Application Ref:	2025/0603			 Ribble Valley Borough Council www.ribblevalley.gov.uk
Date Inspected:	N/A	Site Notice:	N/A	
Officer:	SK			
DELEGATED ITEM FILE REPORT:				NMA APPROVAL

Development Description:	Non-material amendment to application 3/2024/0990 involving change in window/door positions and change of materials on entrance elevation (stone instead of render).
Site Address/Location:	Barrowbridge House Club Street Barrow BB7 9AY

Client Mr S Gill		
Project Proposed Development at Barrow Bridge House Club Street Barrow Clitheroe BB7 9AY		
Drawing Title Plot 1 Proposed Plans and Elevations		
Scale 1:50/100 @ A2	Date Nov 2024	Drawn LFR
READ DESIGN LTD		
161 - 02 B

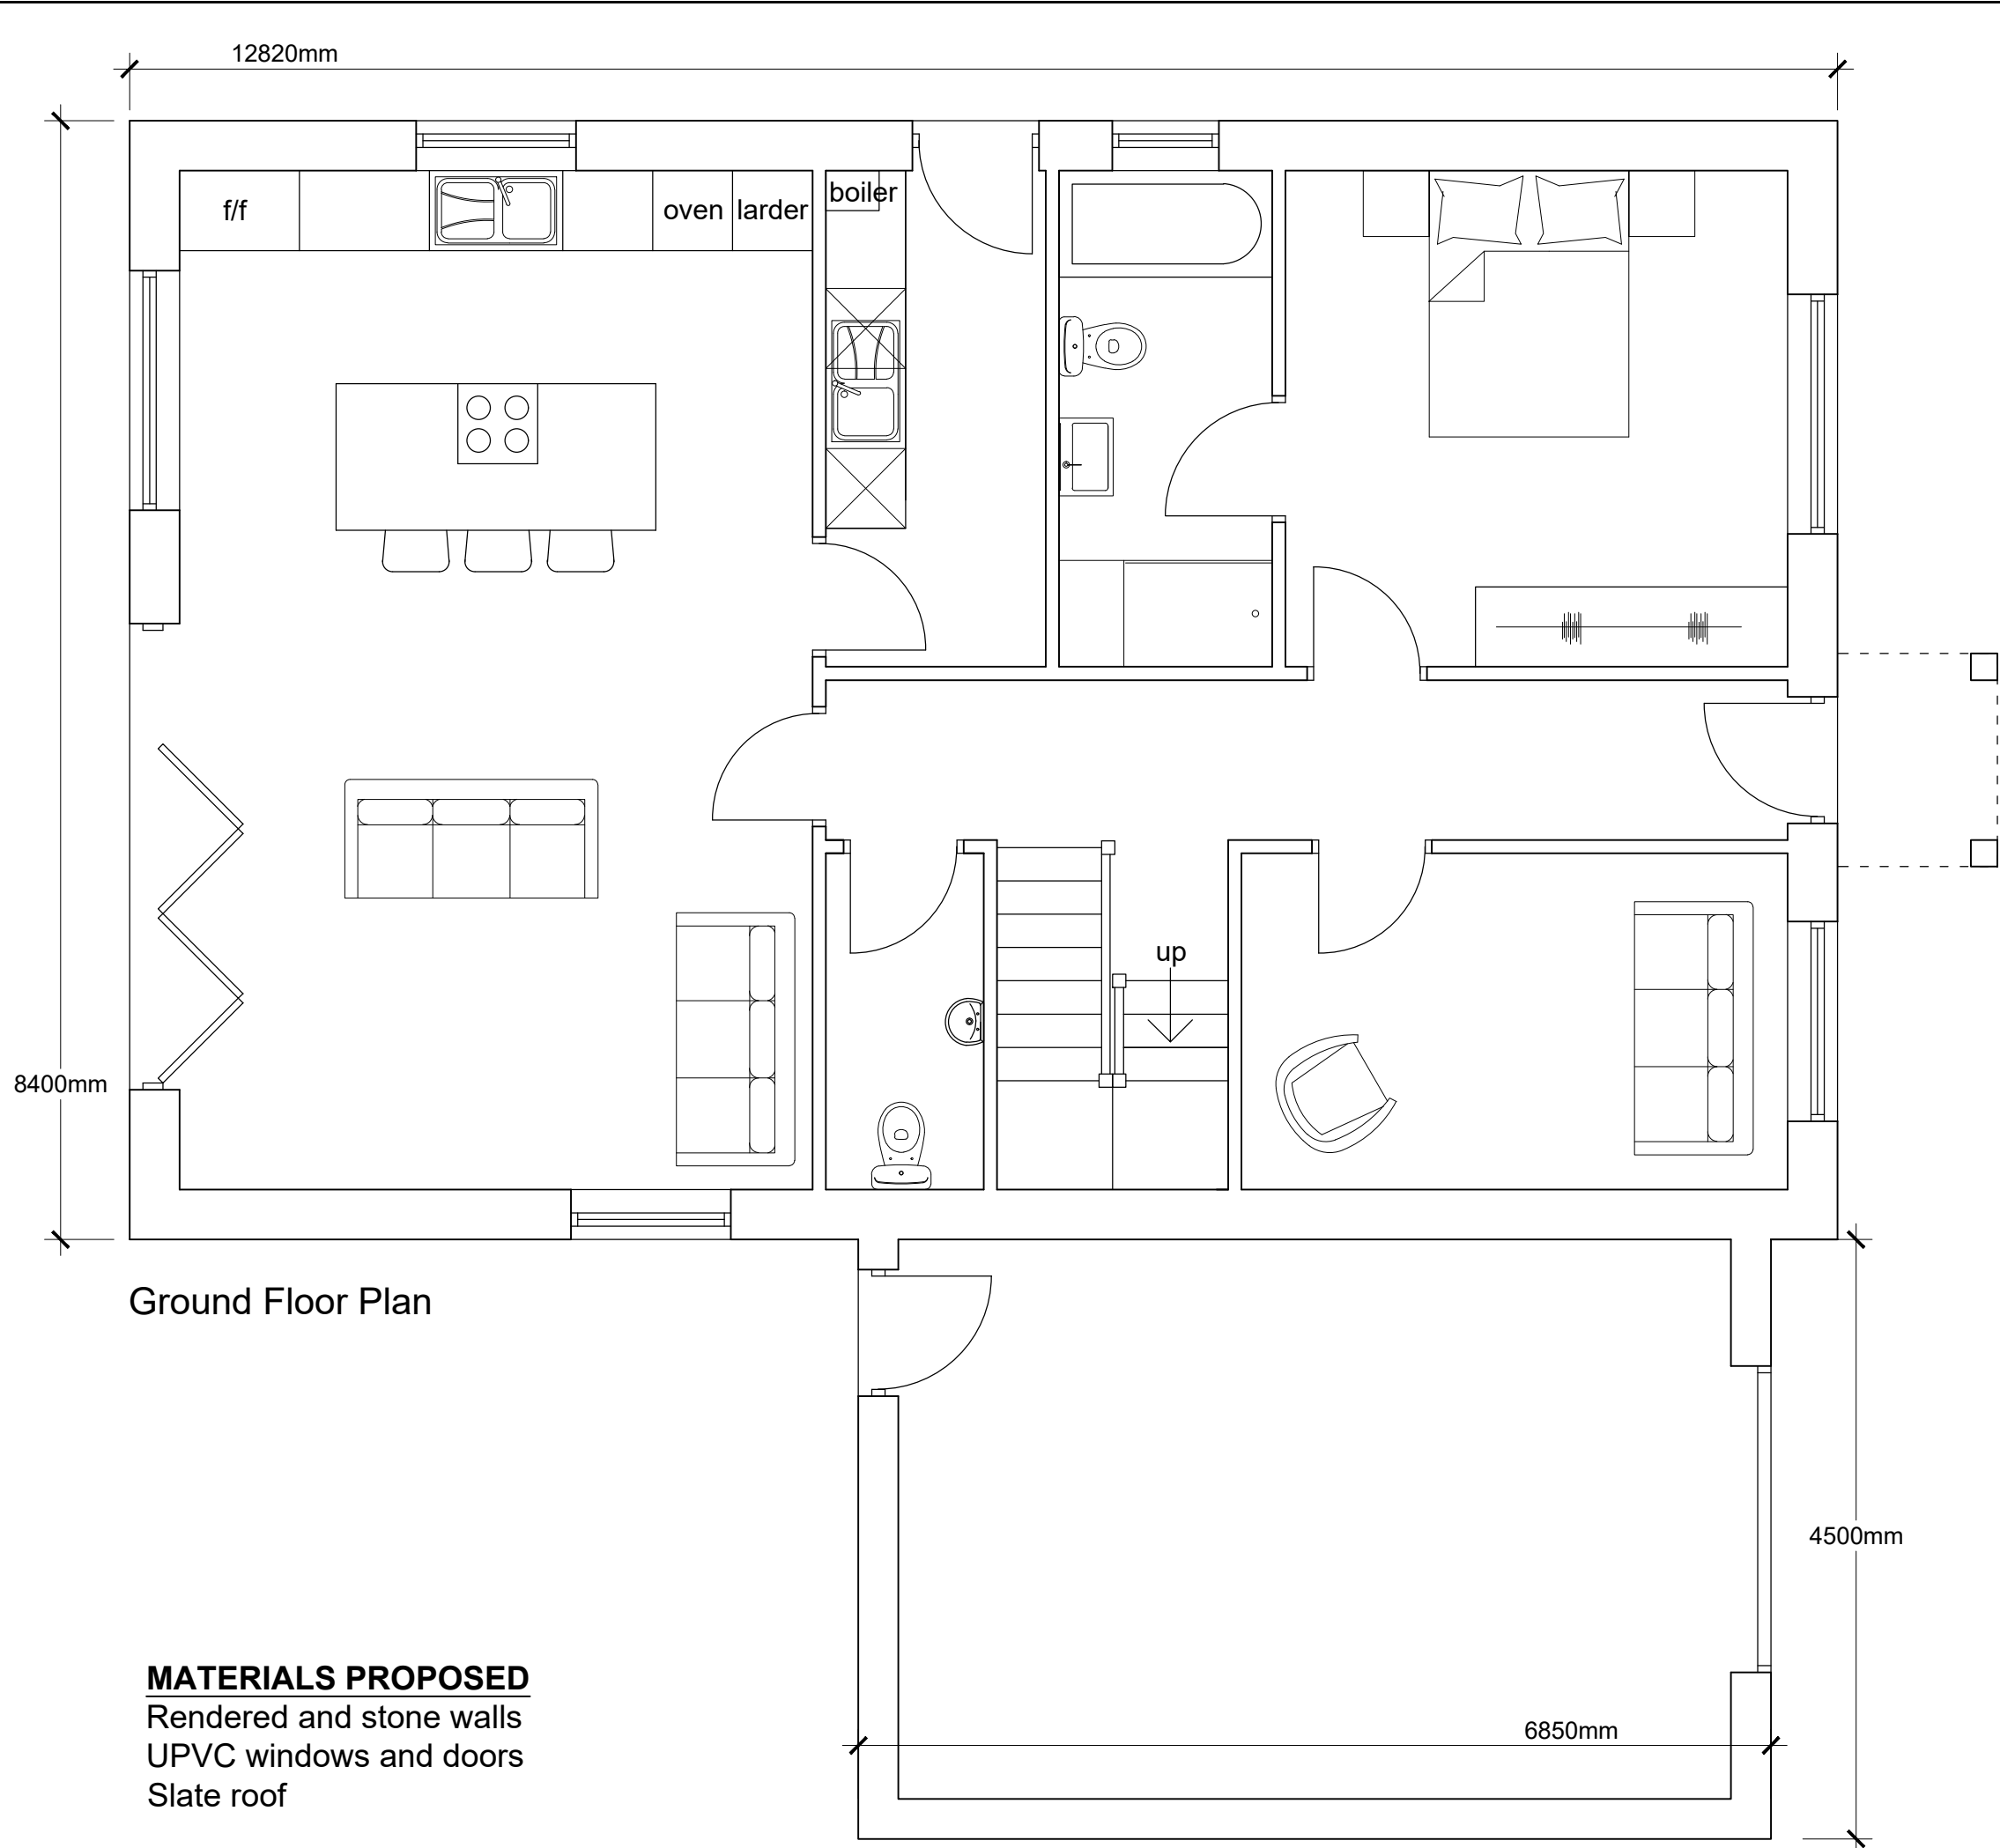
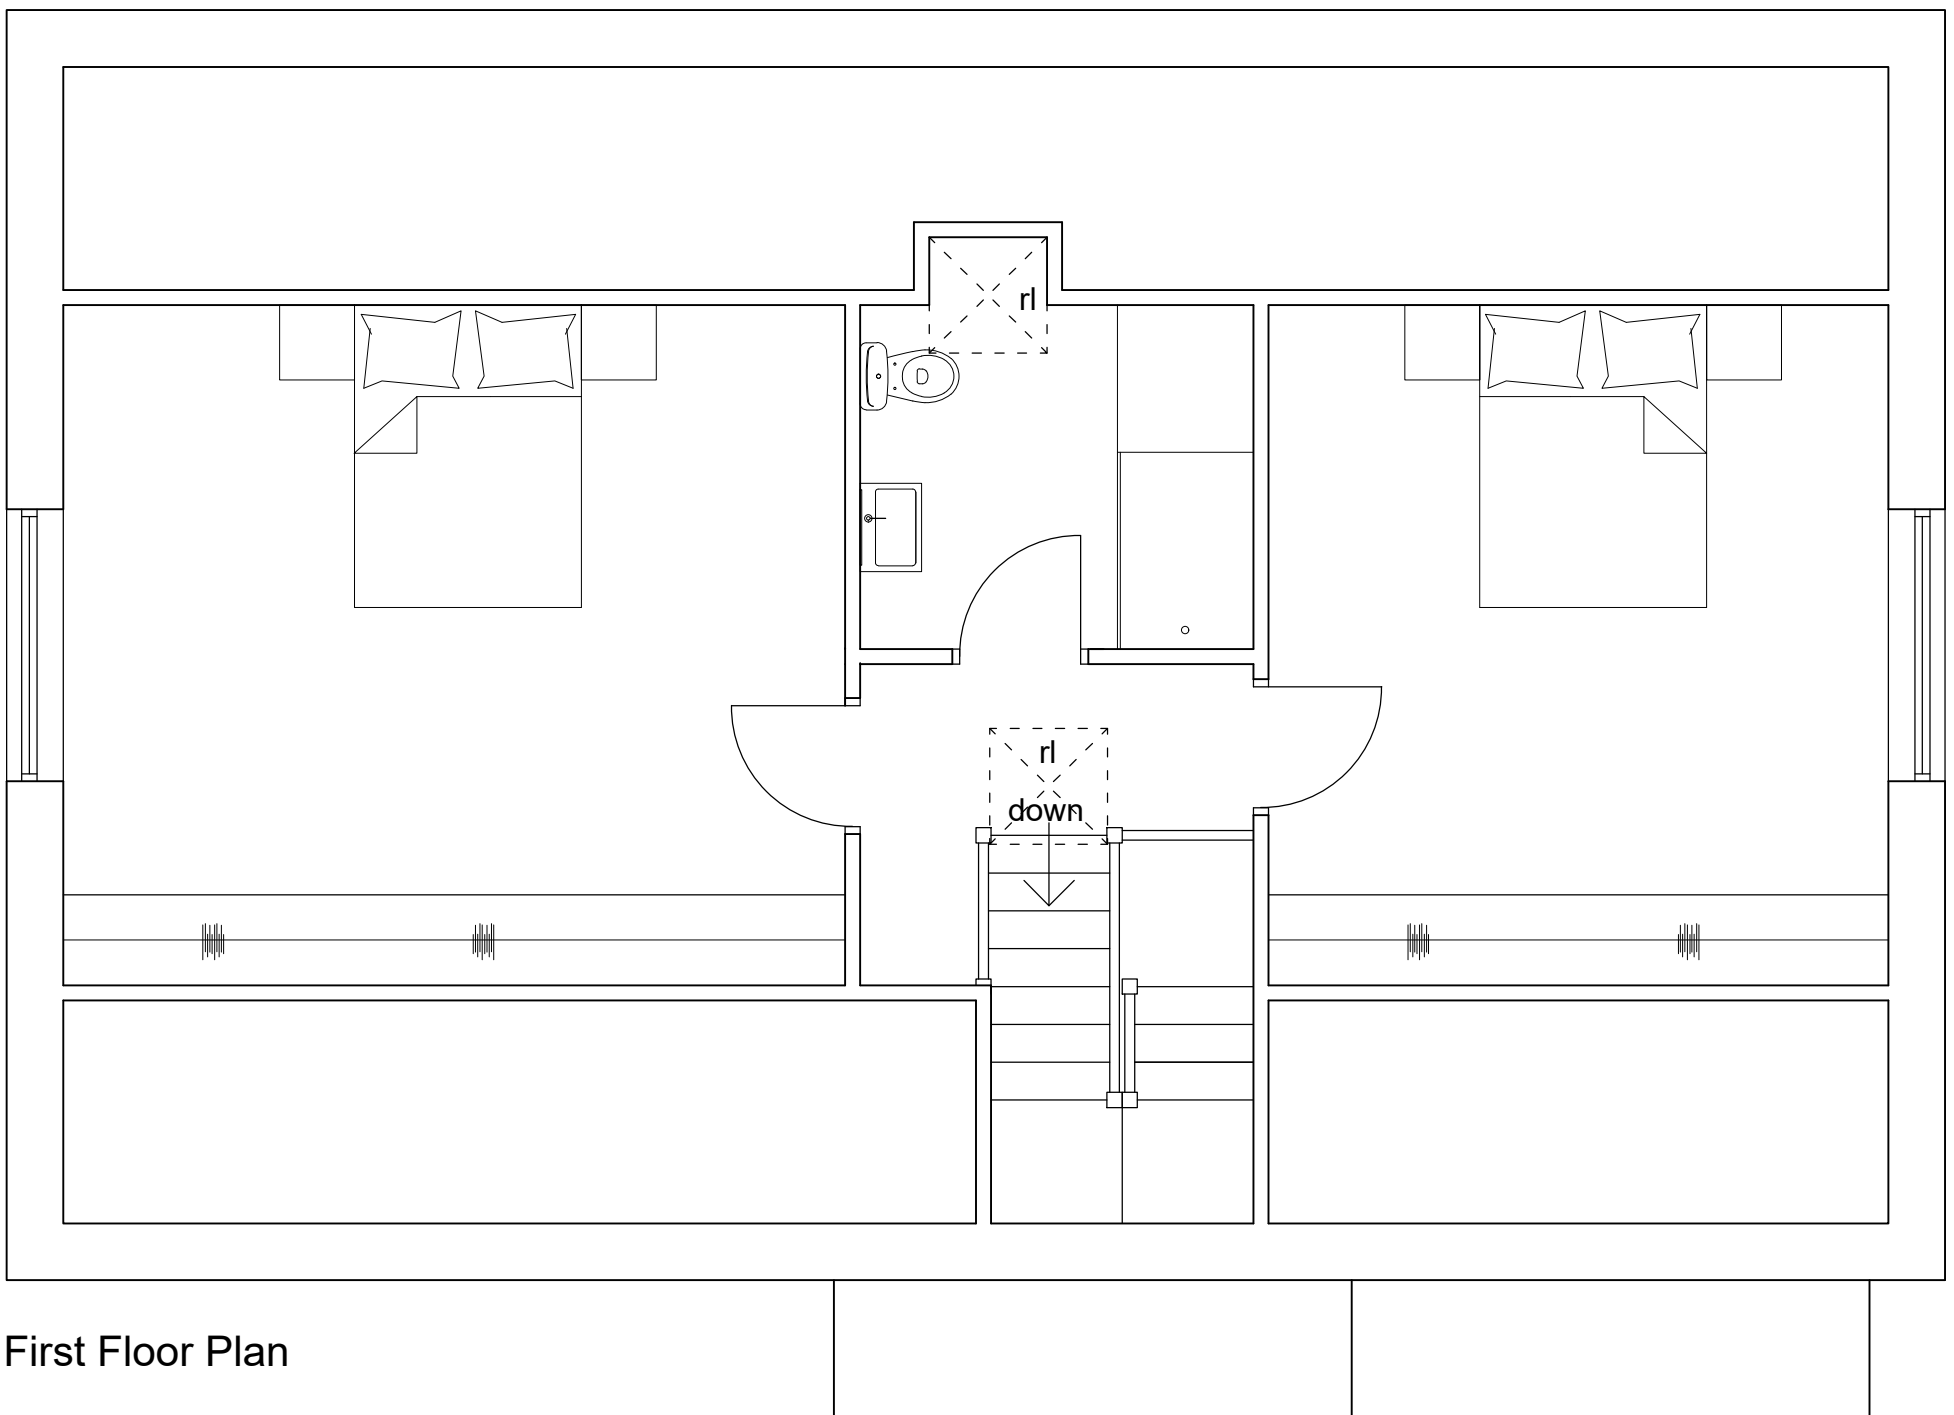
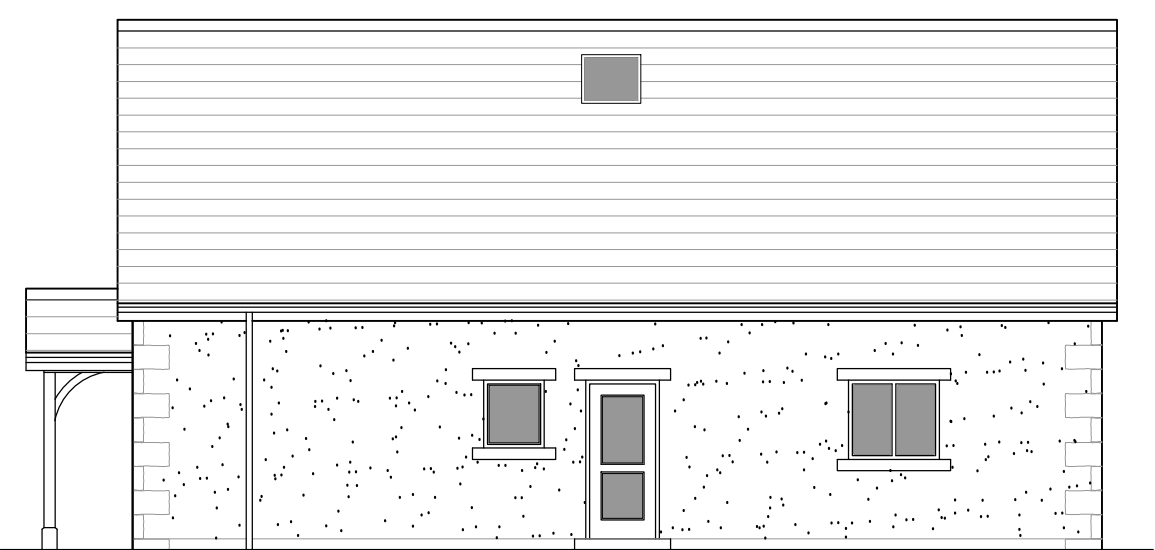
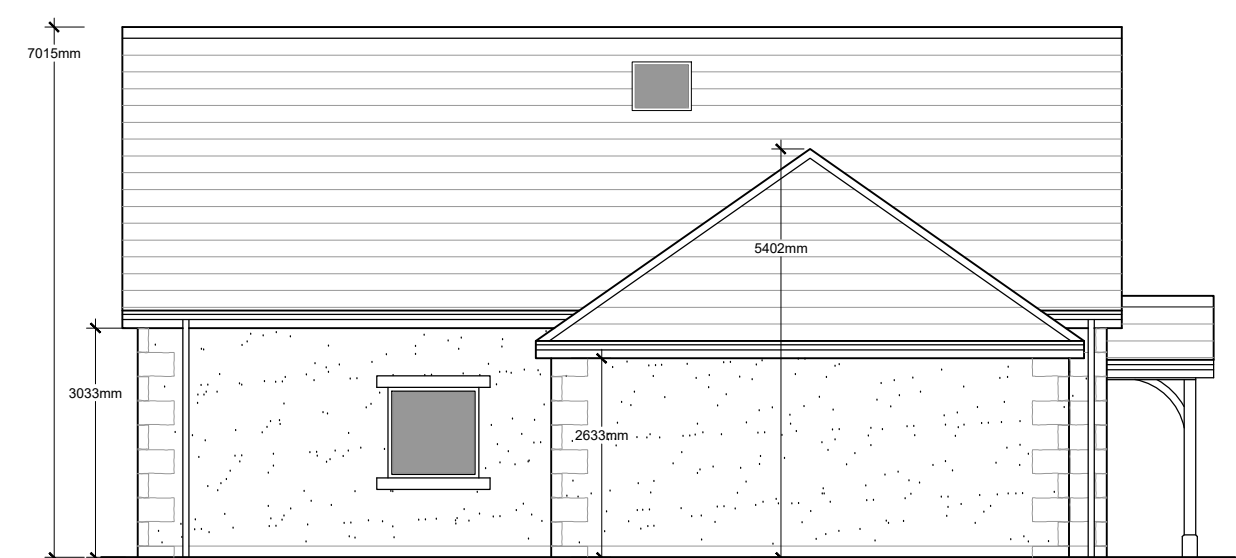
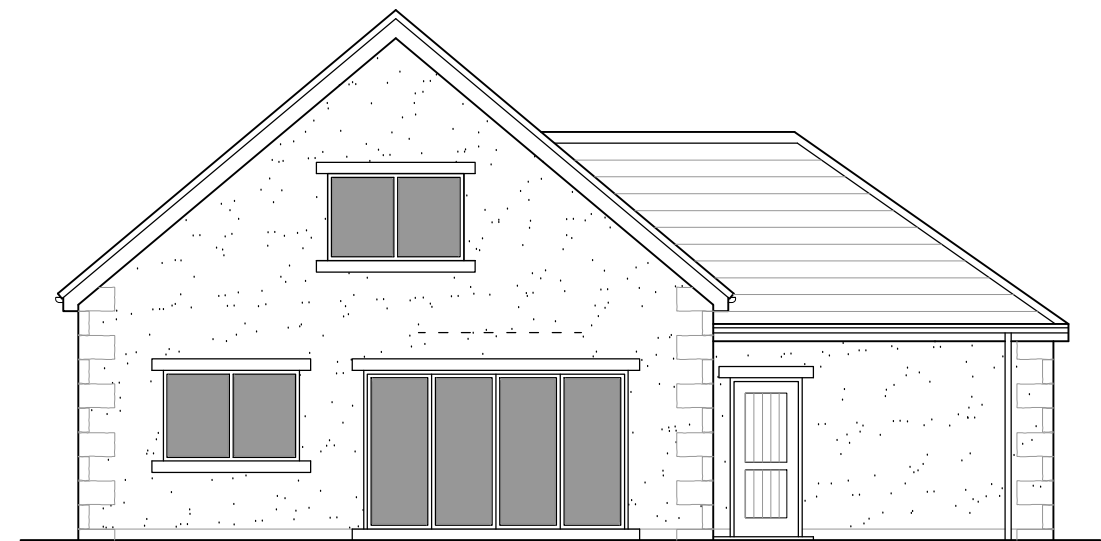
Plot 01:

North-East Elevation:

- Amendment to window locations
- Head and sill detailing added

North-West Elevation:

- Head and sill detailing added

South-East Elevation:

- Introduction of new window at ground floor
- Use of stone on elevation in-lieu of render
- Head and sill detailing added

South-West Elevation:

- Head and sill detailing added

Internal Floorplan:

- Revised location of internal staircase
- Snug introduced at ground floor
- First Floor layout reconfigured
